RE: Papineau (Public Works) Short Plat (SP-17-00001)

Kittitas County Community Development Services has determined that the Papineau Short Plat (SP-17-00001) is compliant with the Comprehensive Plan and Kittitas County Code (KCC) and hereby grants preliminary approval.

PAPINEAU SHORT PLAT

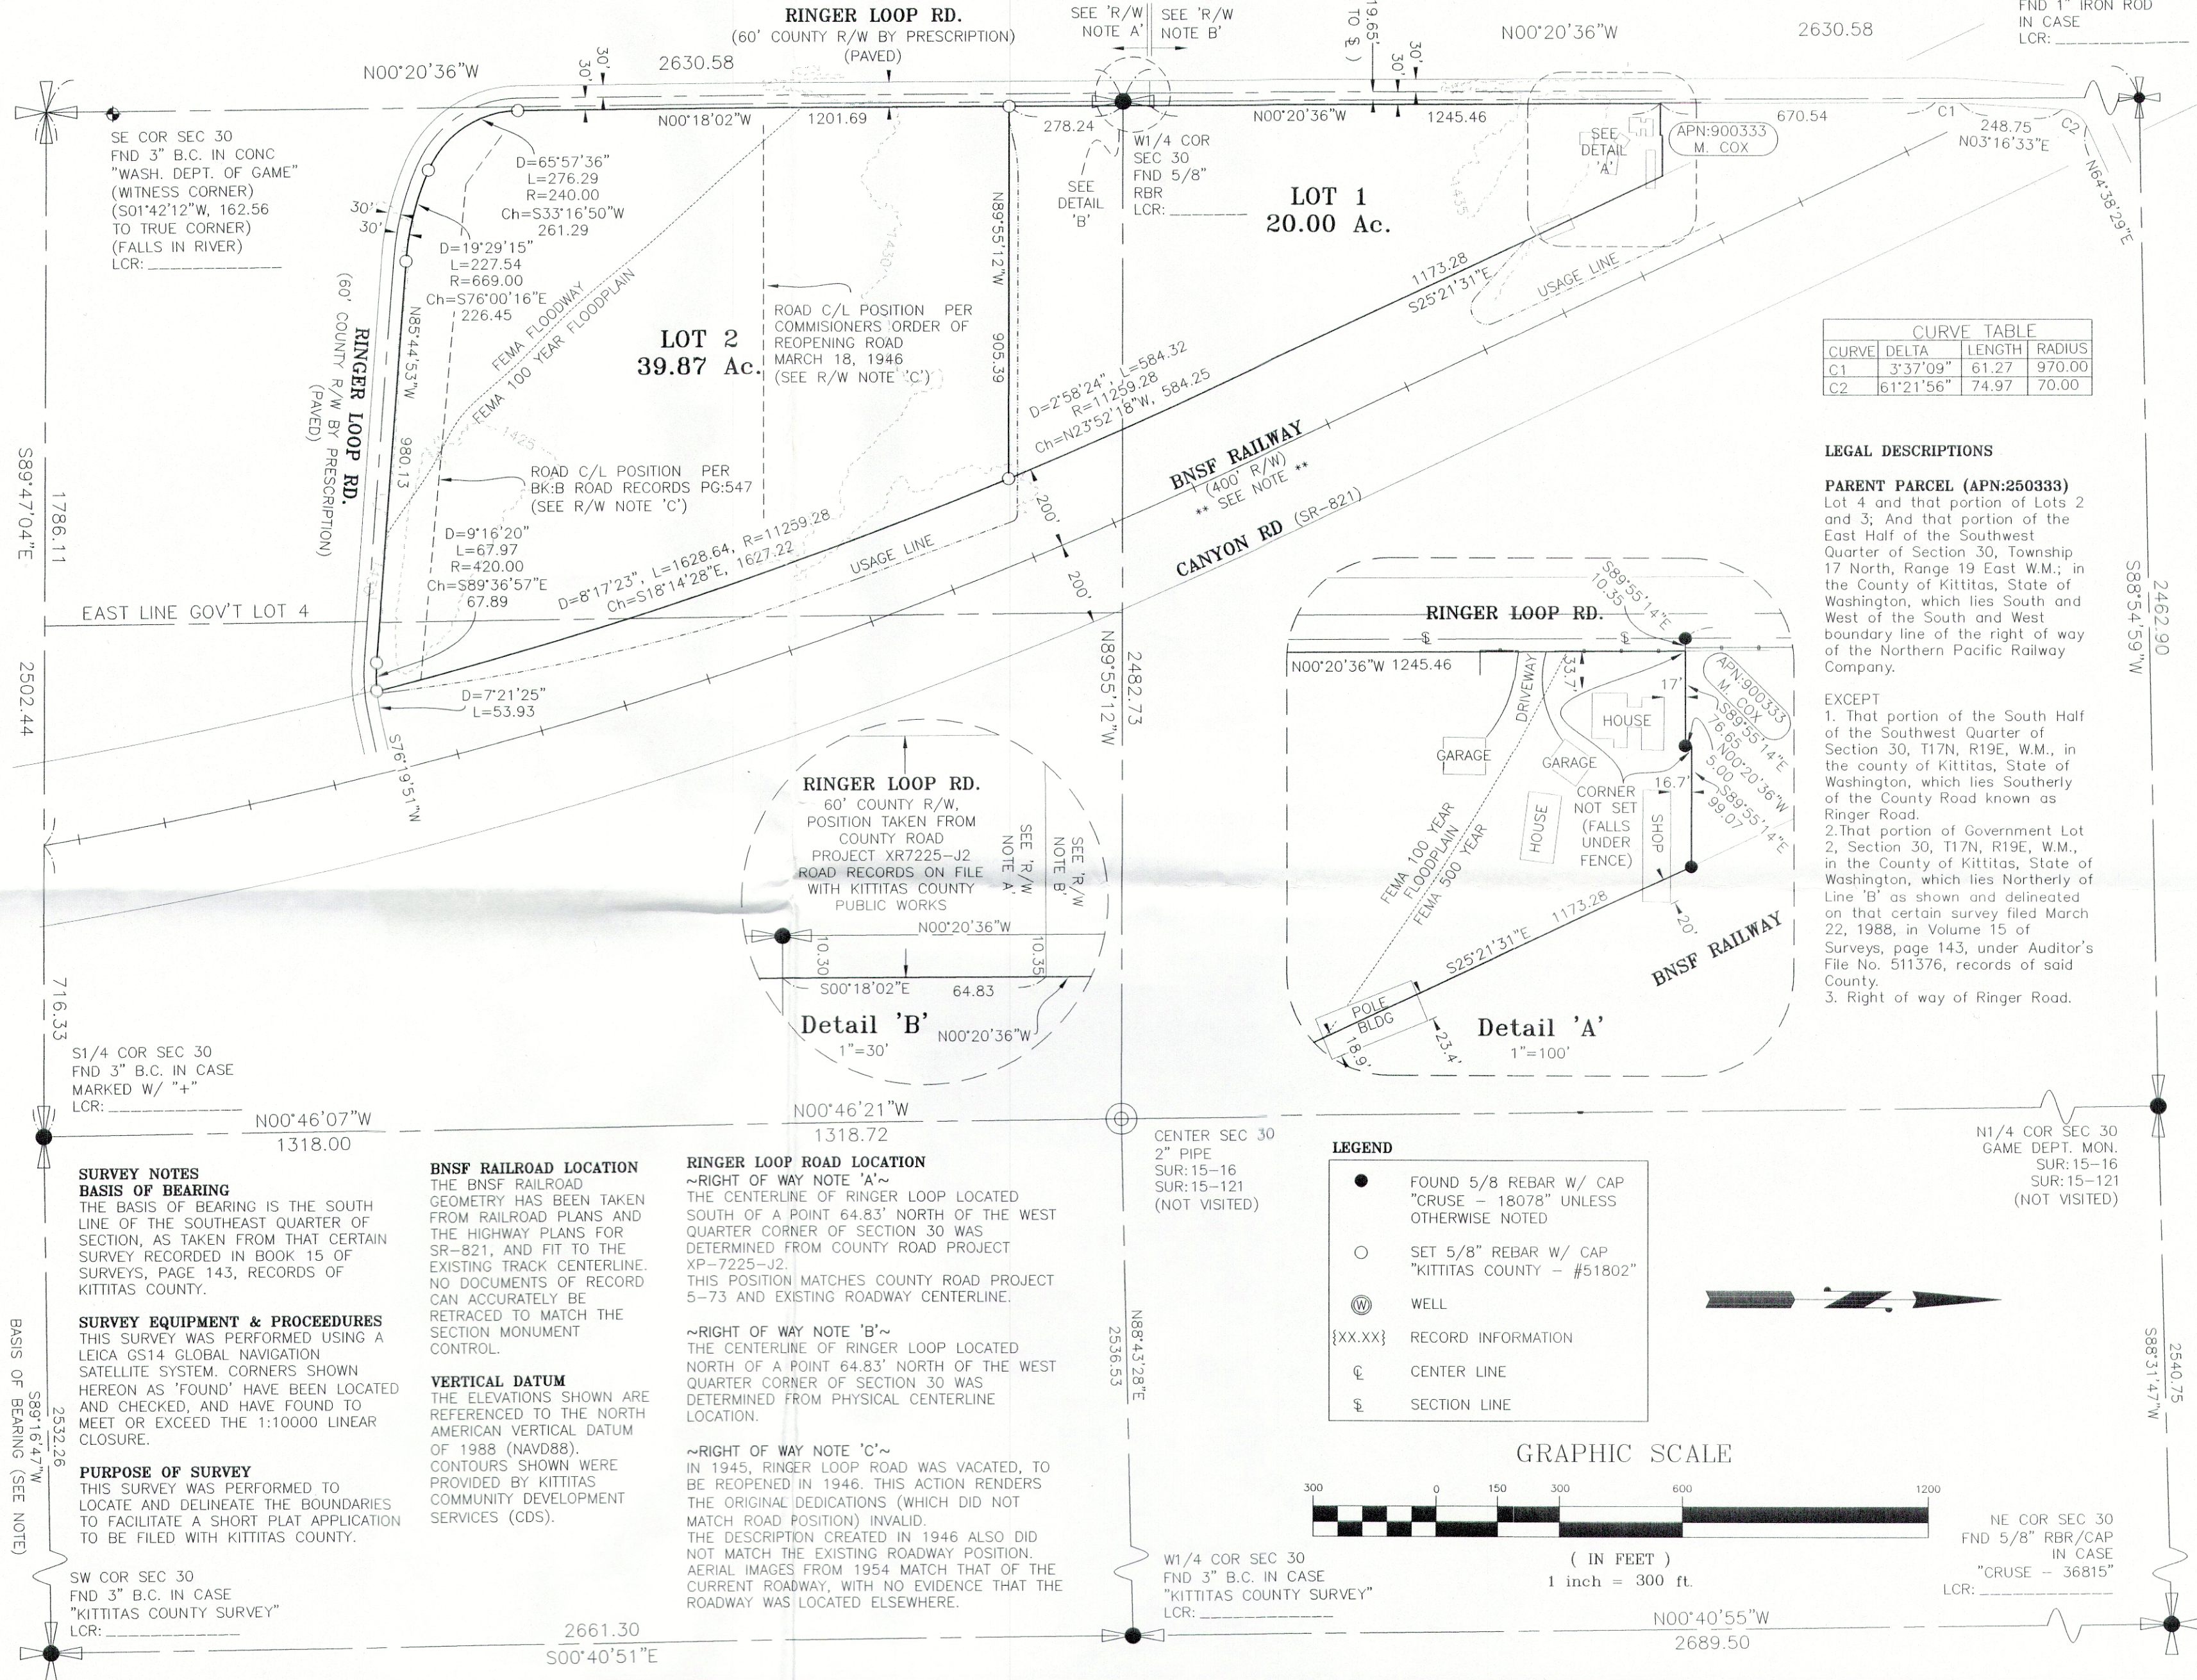
6. National Wetland Inventory Maps show a Freshwater Emergent Wetland crossing both lots **which shall be depicted on the face of the final plat.** All development will comply with buffering and mitigation requirements pursuant to KCC 17A.04.

7. The Kittitas County GIS shows a Type 2 fish bearing stream traversing Lot 1 **which shall be depicted on the face of the final plat.** Any future development, construction, or improvements proposed will observe setback requirements pursuant to 17A.07.
